DRB Application No.: 06DRB-00872 (SBP)	Project # 1004624
Project Name UPTOWN VILLAGE APARTMENTS	
Agent: Denish & Kline Associates.	Phone No.: 842-6461

TO: Sheran Matson, DRB Chair
FROM: Carmen Marrone, Senior Planner
RE: **Project #1004624, Uptown Village Apartments**

On February 16, 2006, the EPC conditionally approved a Site Development Plan for Building Permit for Tract B-2, Saint Pius X Subdivision. **The DRB Site Development Plan does not meet the following EPC conditions:**

**LANDSCAPE CALCULATIONS**

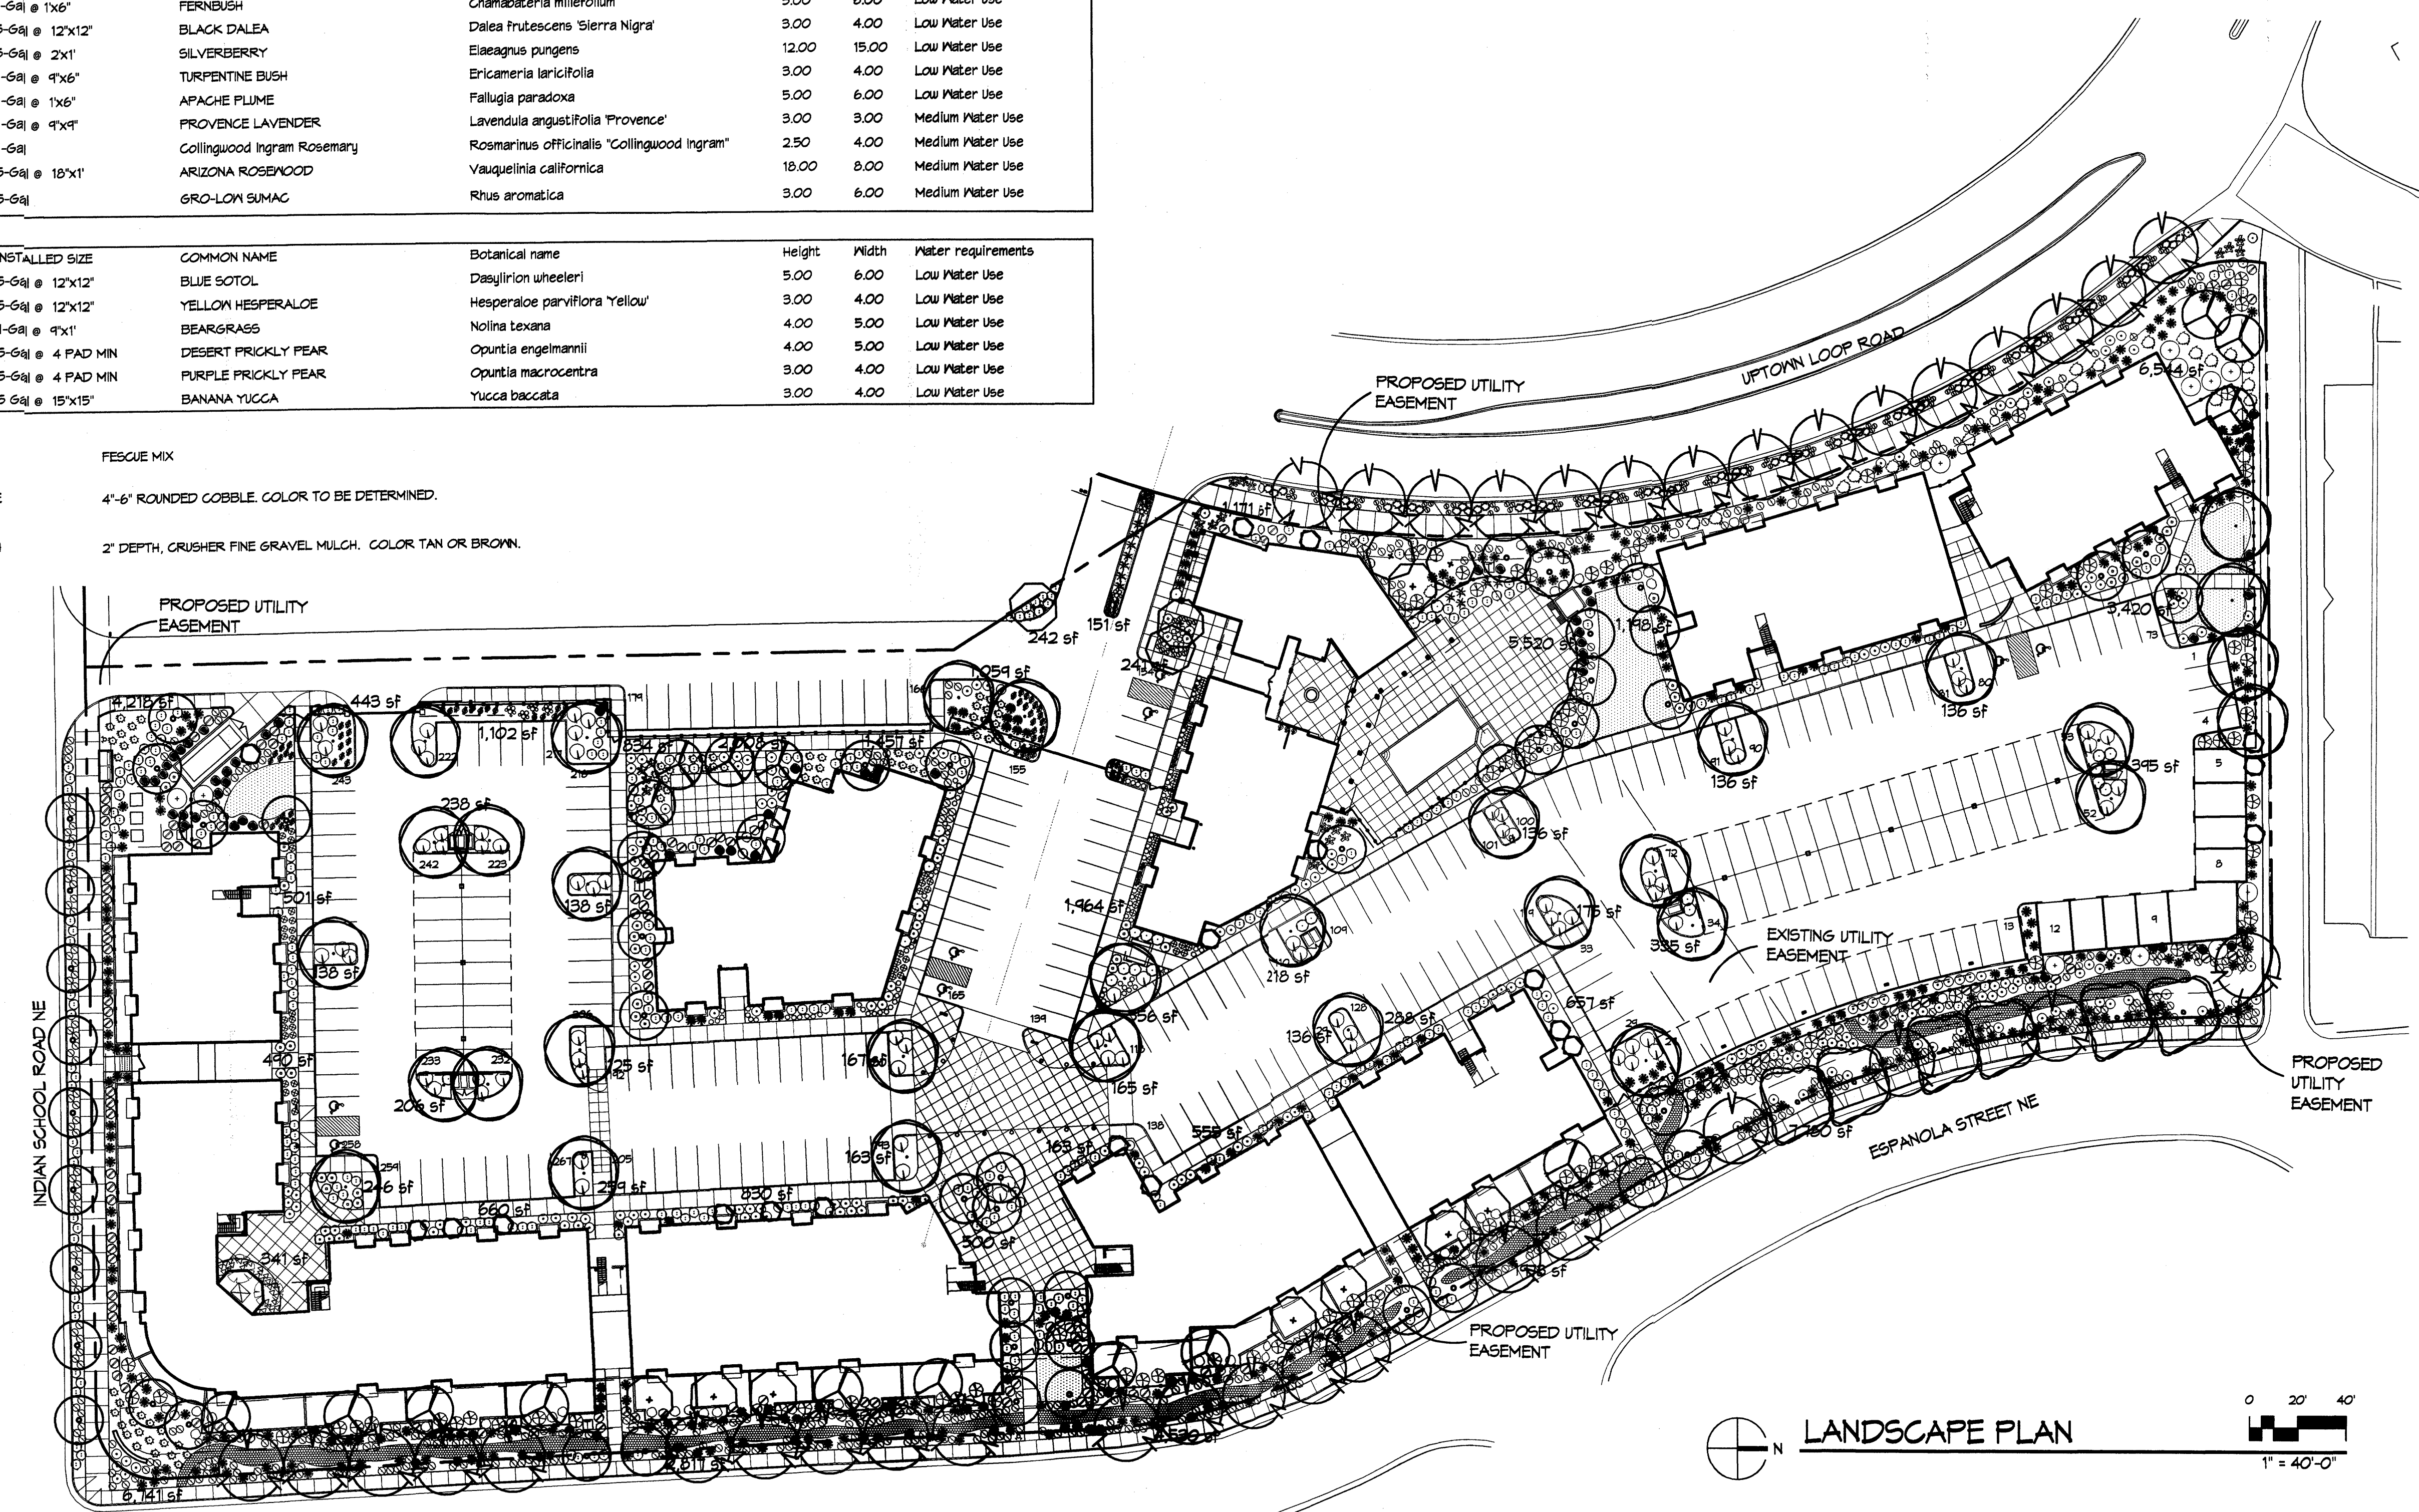
CITY ENGINEER / AMAFCA: encroachment agreement - hot tub
adjust landscape plan (no trees in esmt)
3 copies *(Signature)*

✓ **Condition 2:** The revised site plan proposes only one additional tree, a Desert Willow tree along the Arvada Trail. The condition calls for additional shade trees (plural) along this trail.

✓ **Condition 12:** Patio trees are required in each patio fronting Espanola. These are not indicated.

DRAWN BY	CM
REVIEWED BY	JLM
DATE	06.13.06
PROJECT NO.	05100
DRAWING NAME	CONCEPTUAL GRADING AND DRAINAGE PLAN

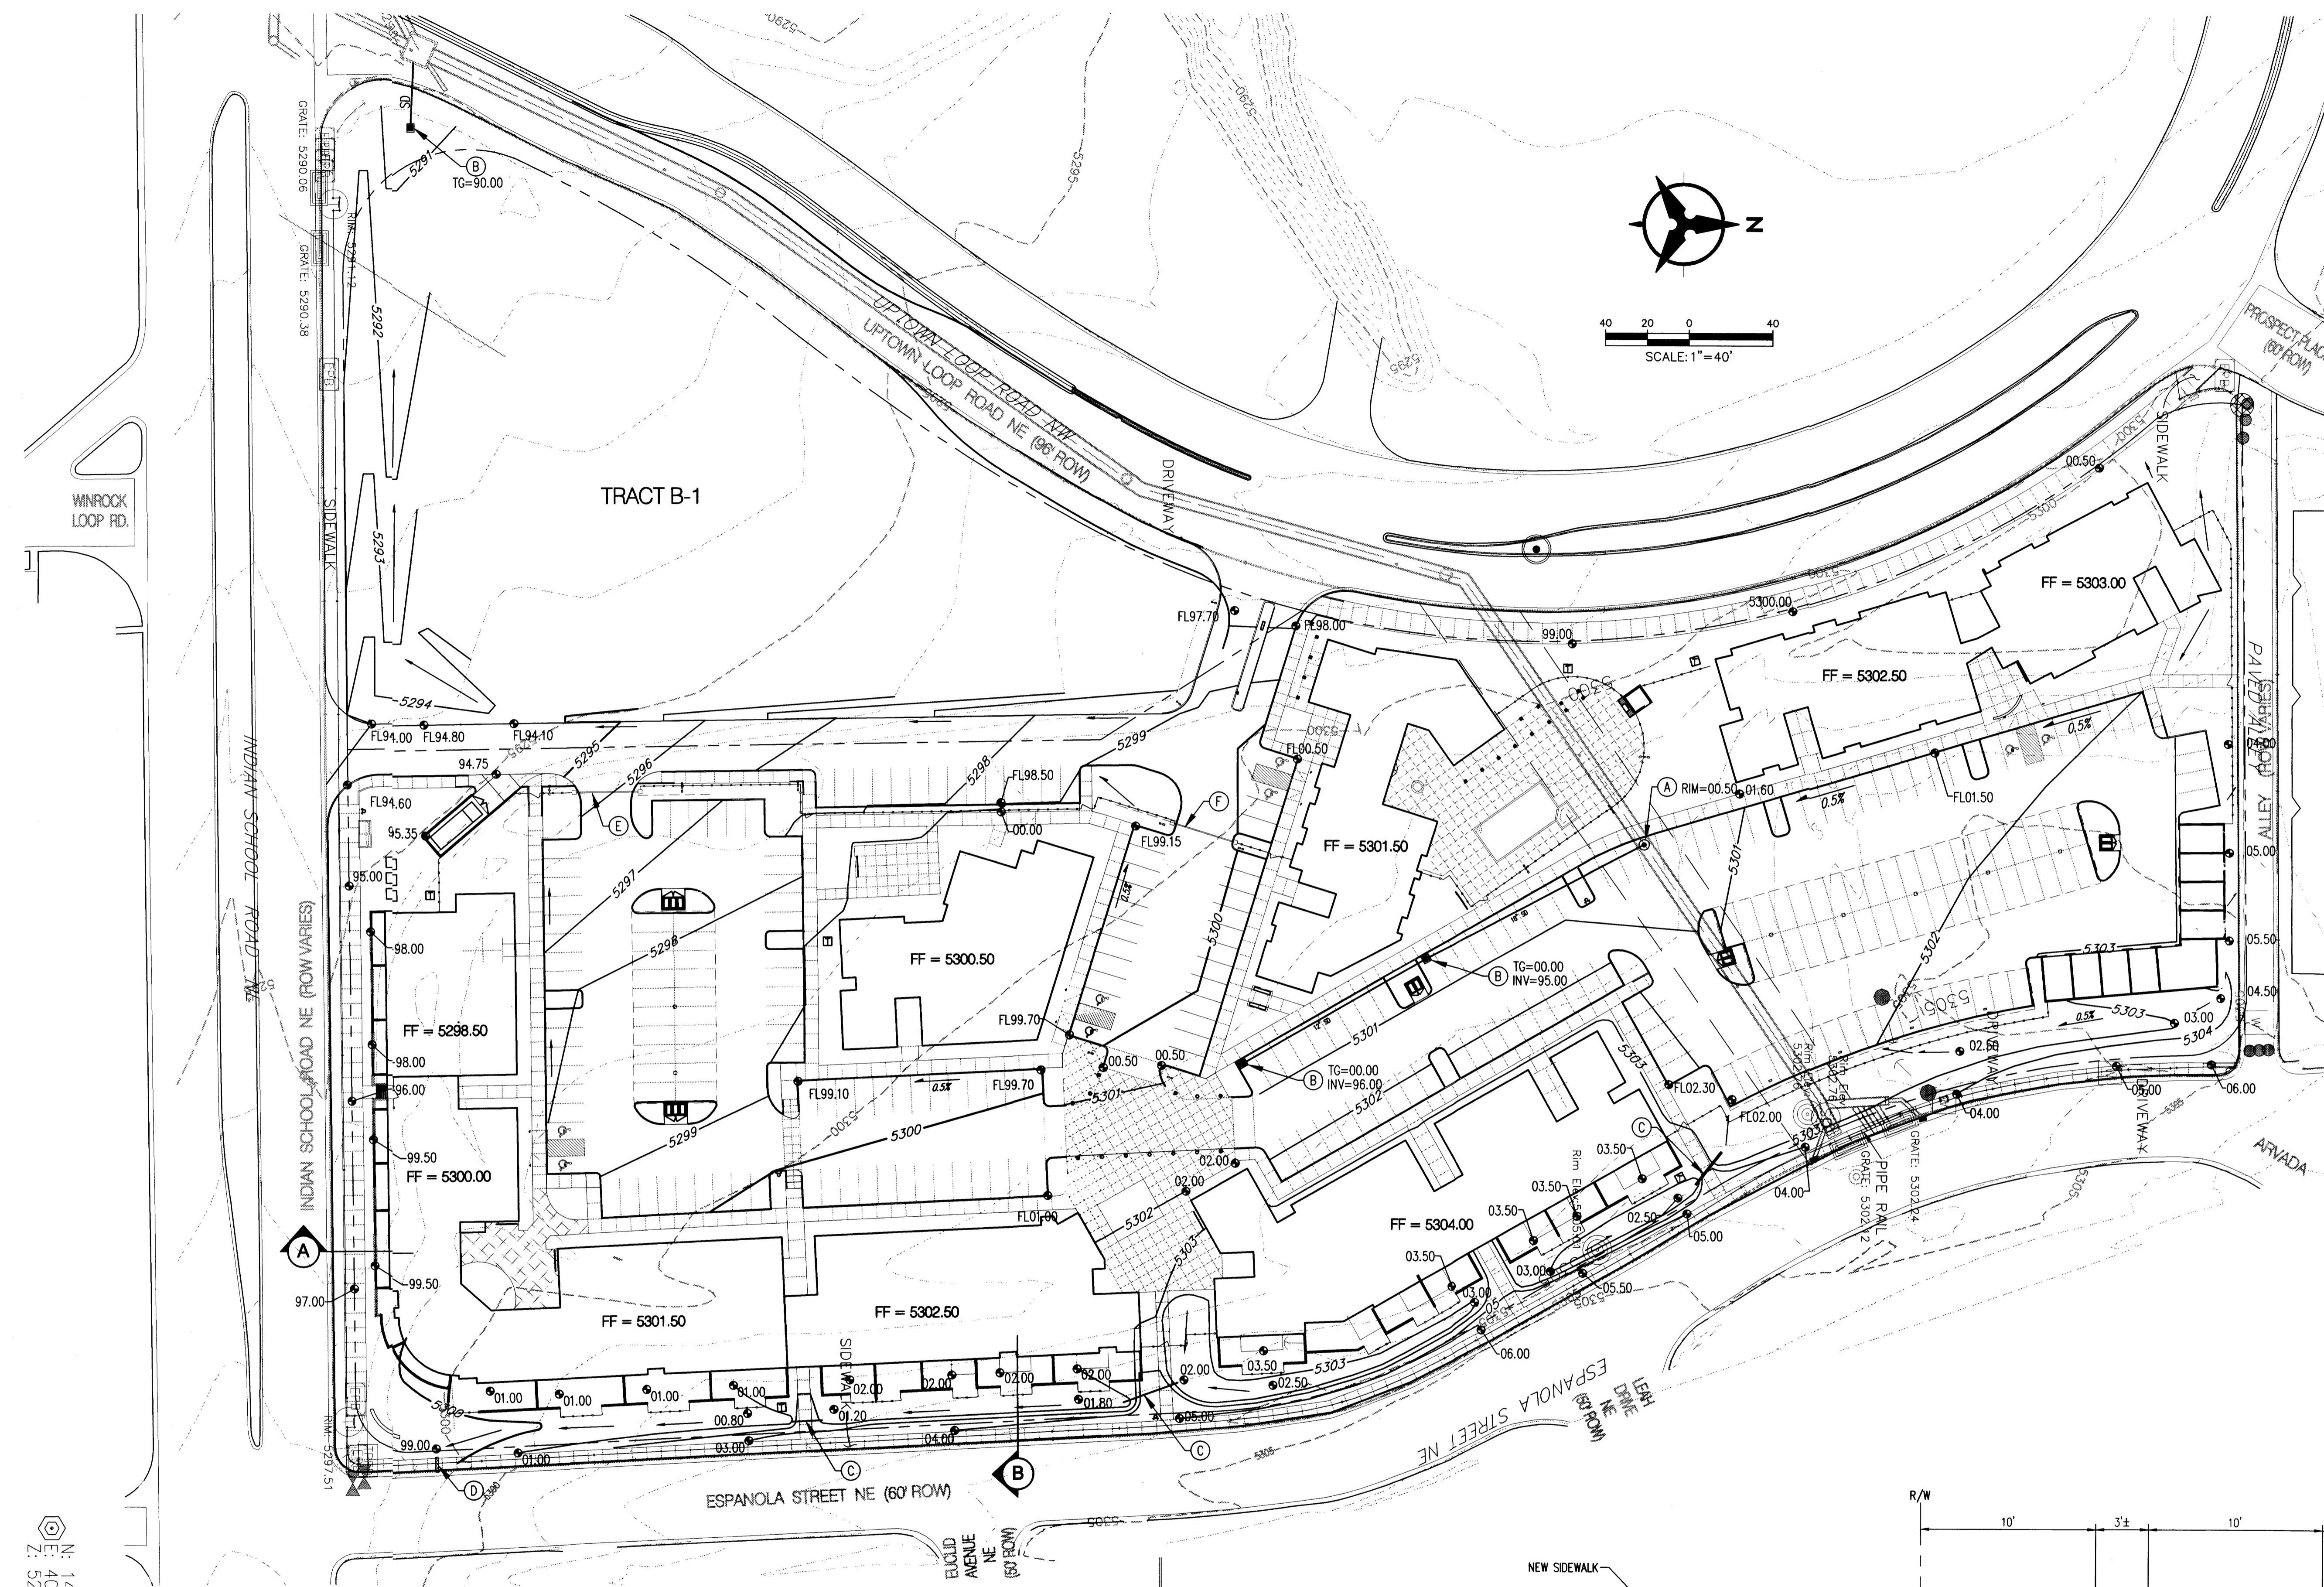
No hot tub encroachment in storm drain easement. Needs to be labeled as storm drain easement.

No hot-tub encroachment into storm drain easement.

**C1 NORTH ELEVATION**  
BUILDING B

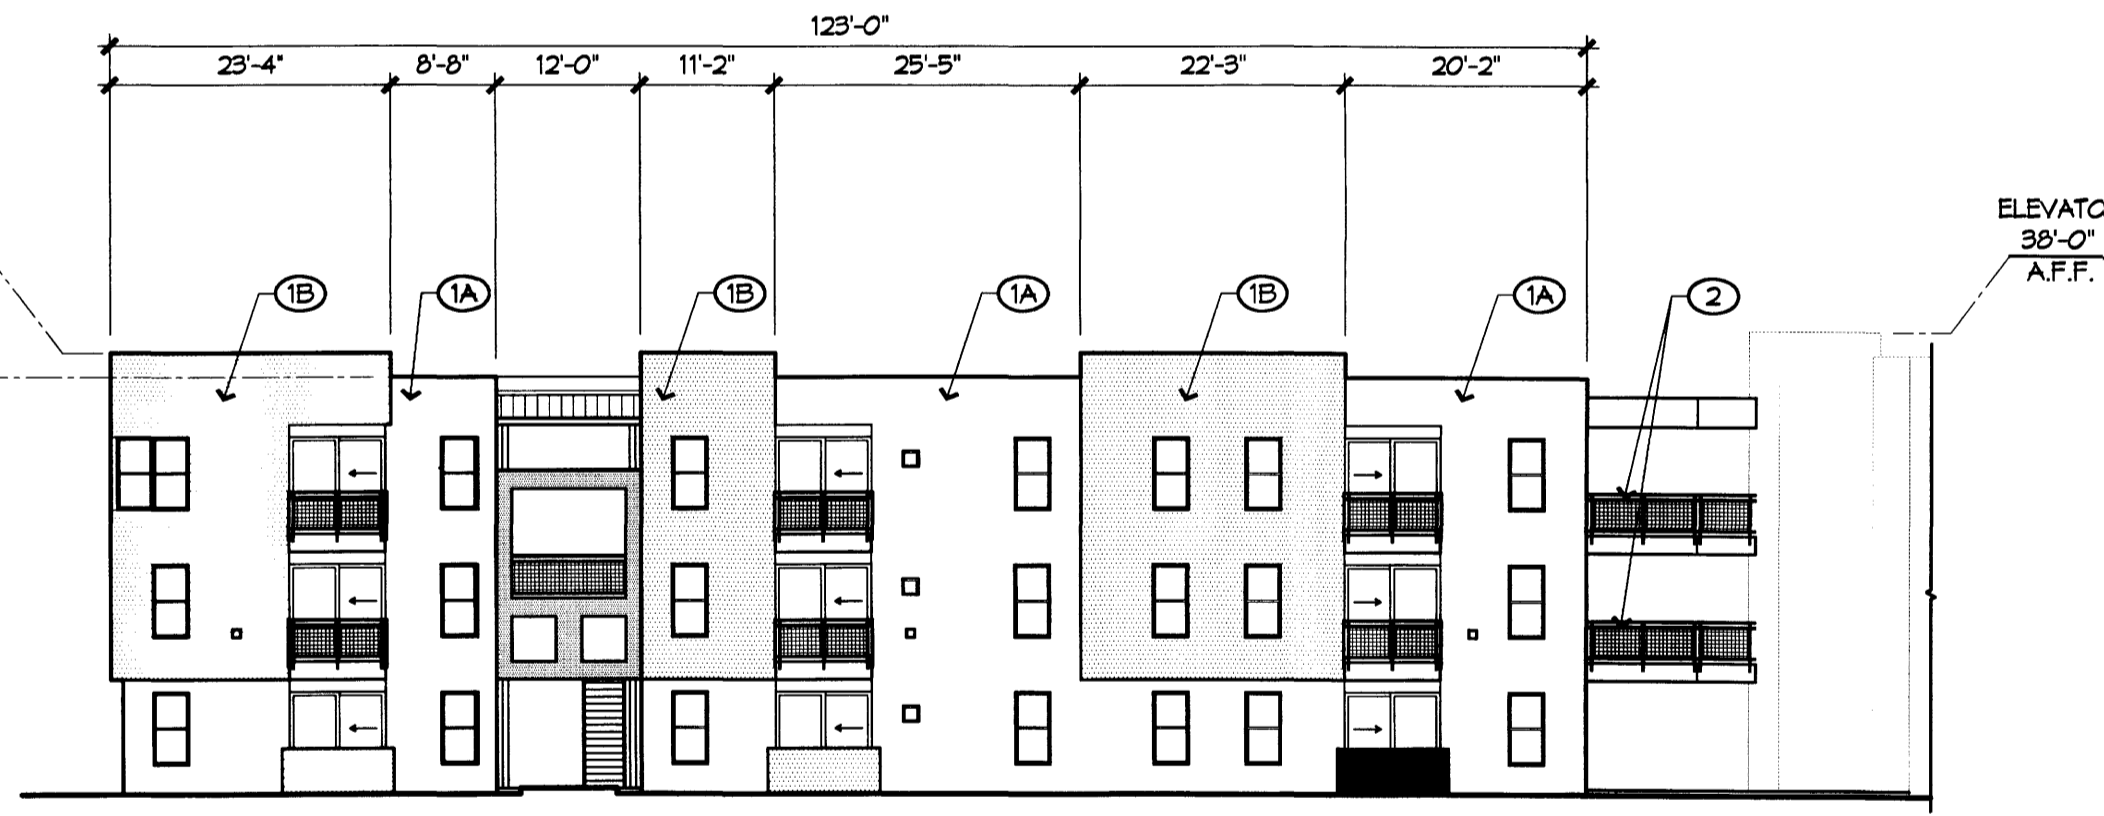
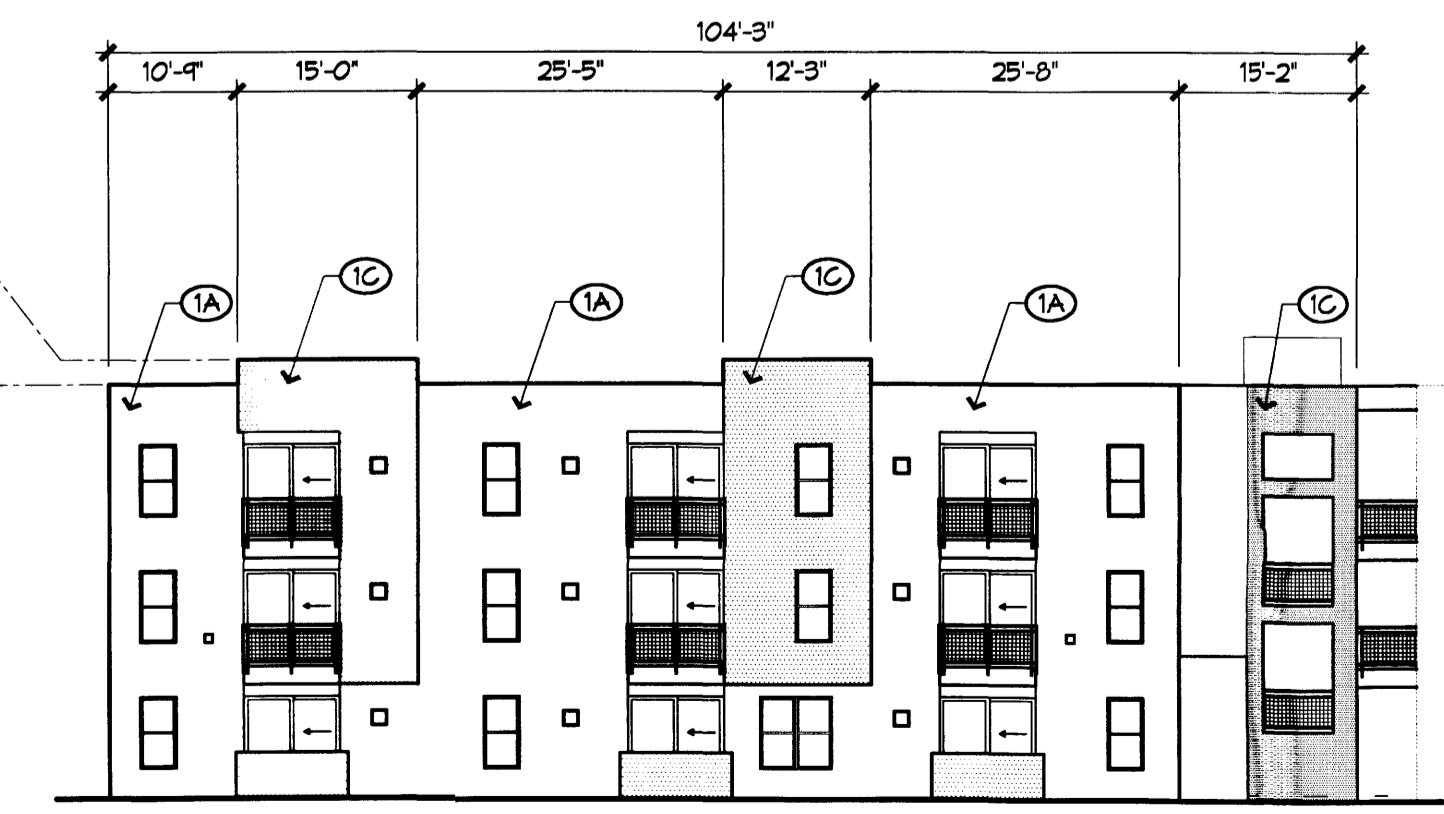
— **Condition 9:** Two North elevations are shown for Building B on Sheet A301, Detail C1 and D1. Is one of these the South elevation?
